October 26, 2011

**Re: Spectrum Assisted Living Drainage Report and Grading and Drainage Plan
Engineer's Stamp dated 10-12-11 (A12/D025)**

PROJECT TITLE: Spectrum Assisted Living Facility
DRB #: 1008528 EPC #: 11EPC-40040/40041

SPECTRUM ASSISTED LIVING		DRAWN BY	
GRADING AND DRAINAGE PLAN		BJF	
DATE		1/20/12	
2011026-C3-GRB		SHEET #	
C3		JOB #	
2011026

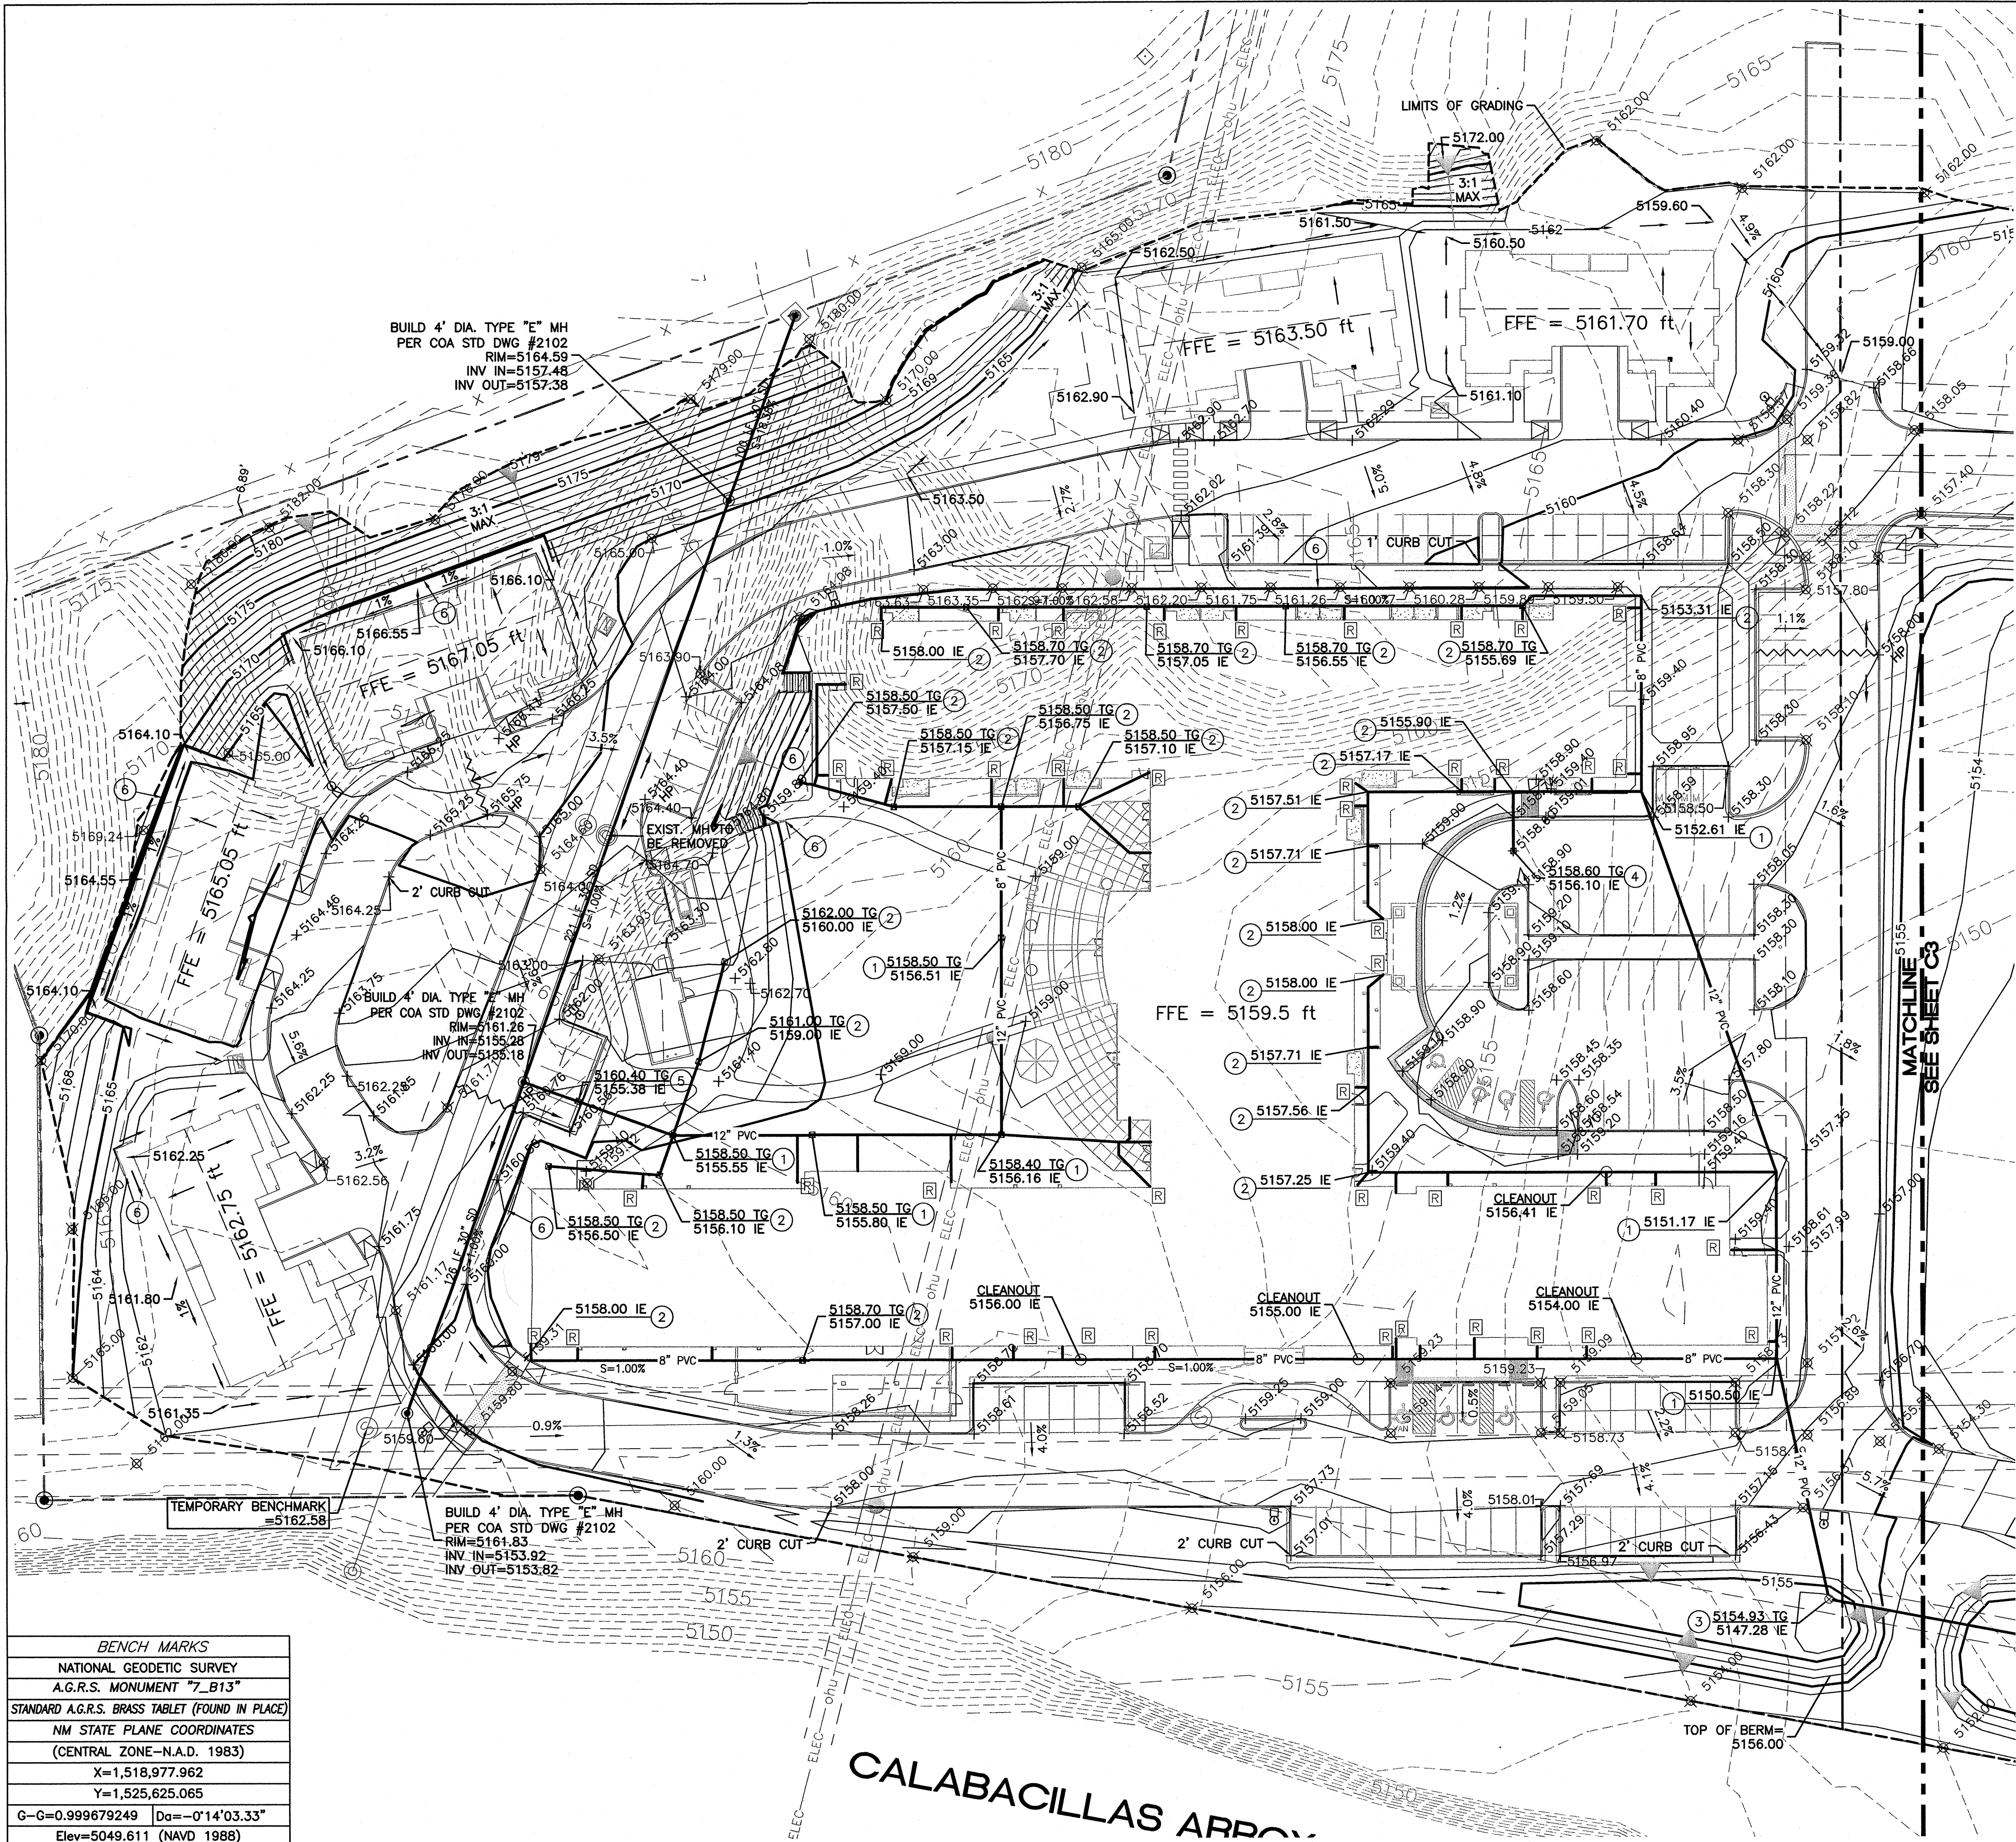
- Hydrology would like to see the basin divides and all the inlets on this plan.
- The LEGEND has dashed line types for existing contours, but existing contours are shown as solid lines, making it difficult to determine the difference between existing and proposed.
- Is the dashed line around the project the limits of construction?
- The plan should be labeled as "Conceptual Grading and Drainage Plan" rather than the Grading and Drainage Plan, since it is too conceptual to be certified.
- The grades shown on the Smith's site indicate a large offsite basin, when there is only a small portion of the Smith's site that drains onto this site.

- The Grading and Drainage Plan for the west lot was not reviewed due to above comments and that Building Permit was not applied for.
- A separate sheet should be submitted for grading/flat work on the east lot.
